Application for a non-material amendment following a grant of planning permission.
Town and Country Planning Act 1990

TWO STOREY FRONT EXTENSION

AW 26/20/HH

INCREASE IN WINDOW SIZE TO THE MAIN BEDROOM

sheet 2 c of 3

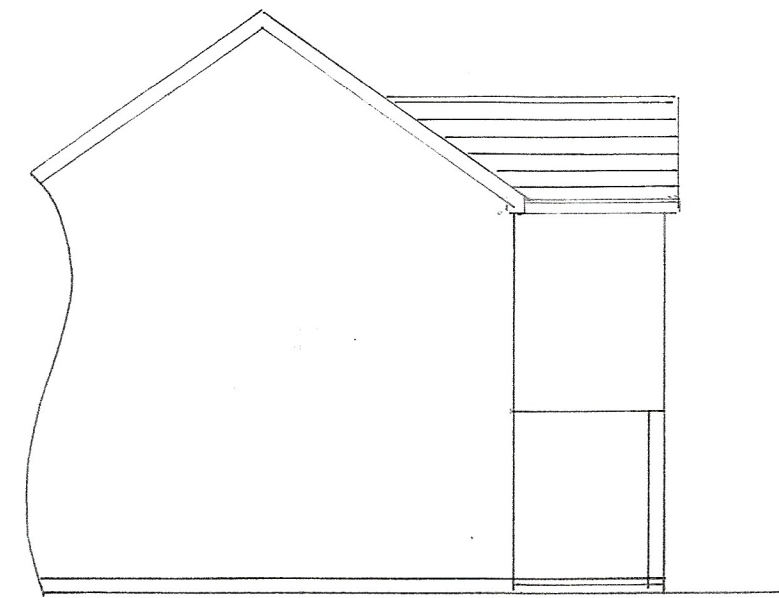
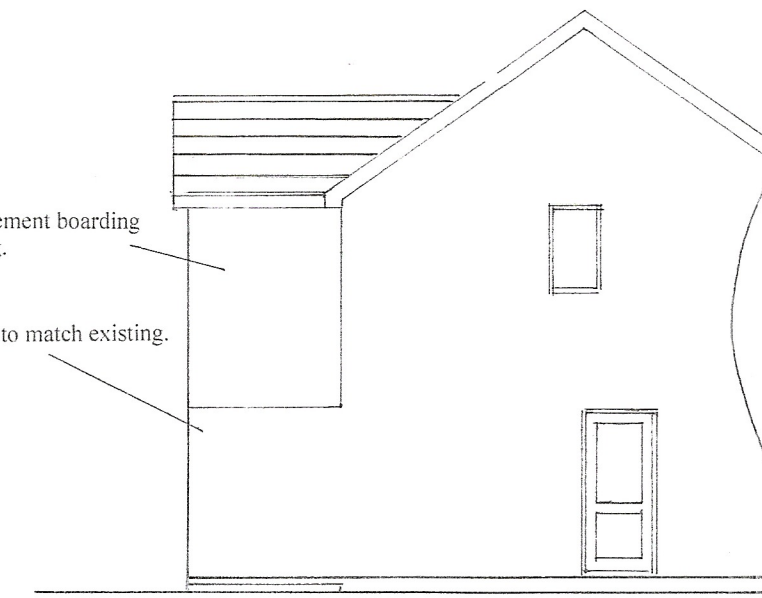
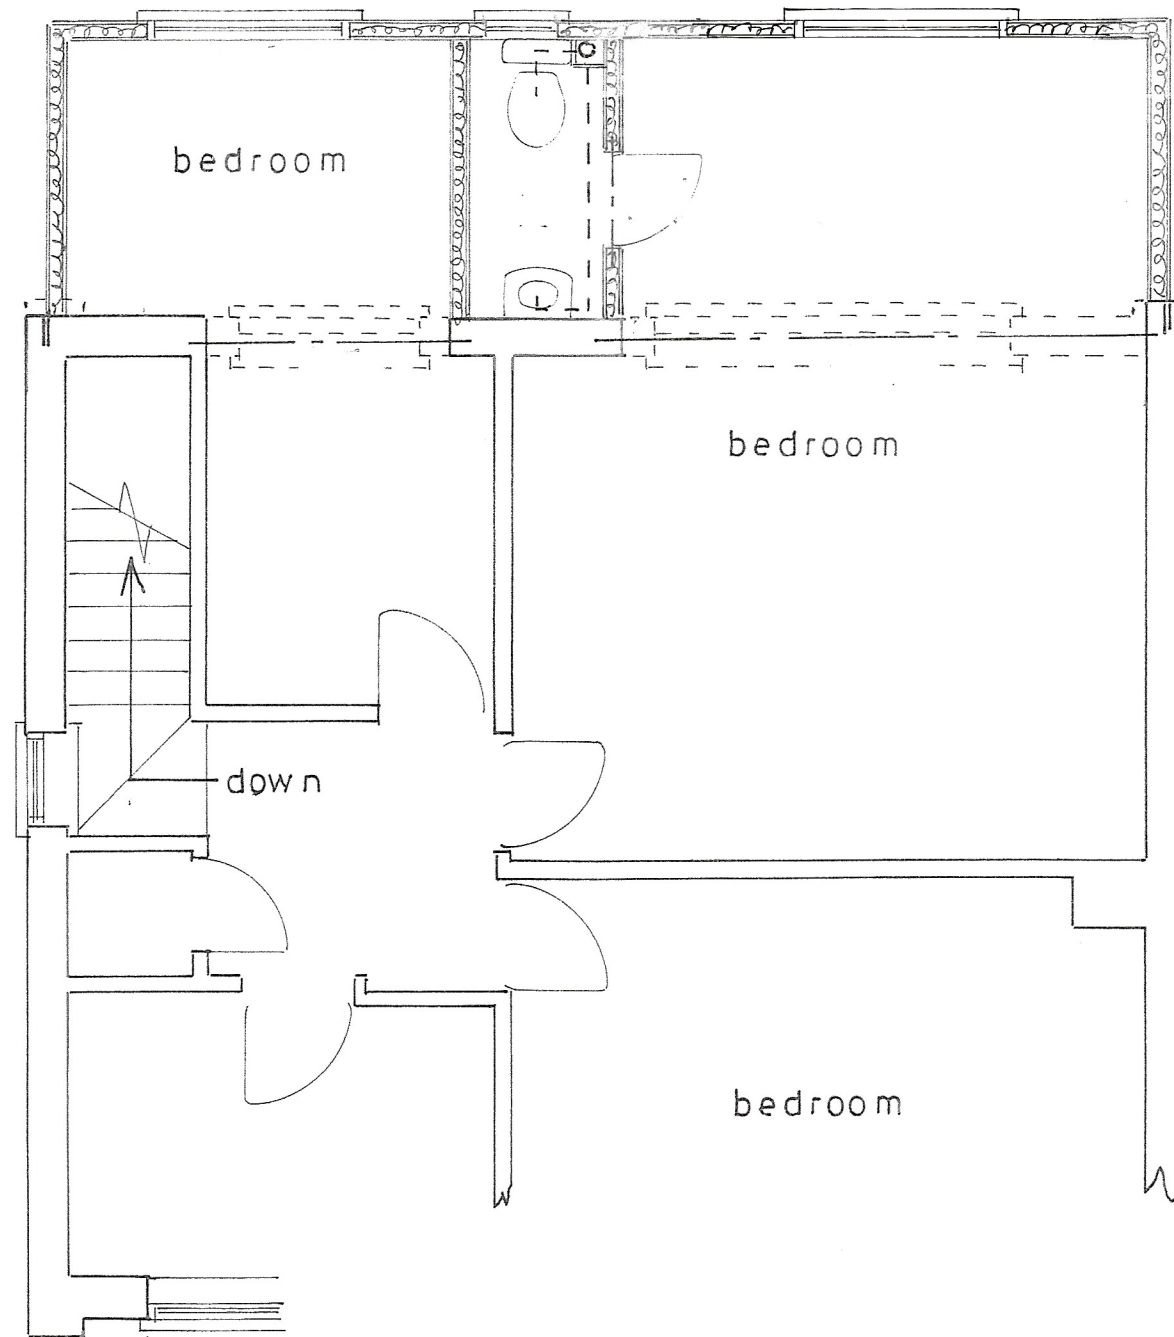
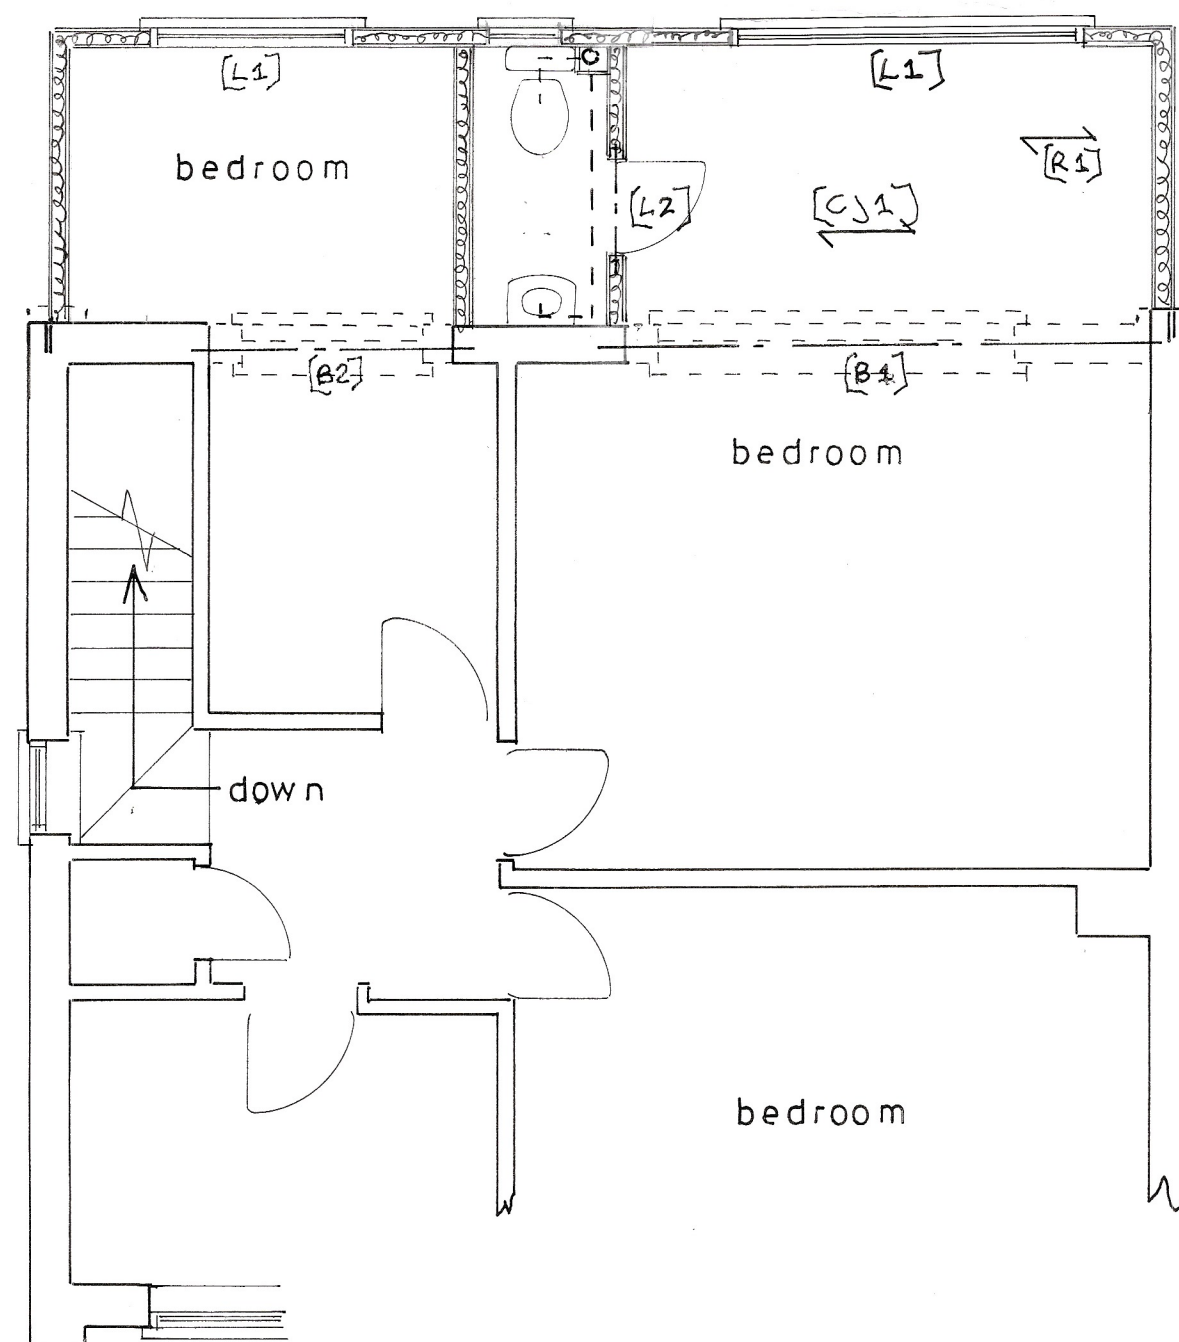
Sheets 1a, 2b & 3a

Sheets 1a, 2c & 3a

TO INCREASE LIGHT AND RE-USE EXISTING WINDOW FRAME.
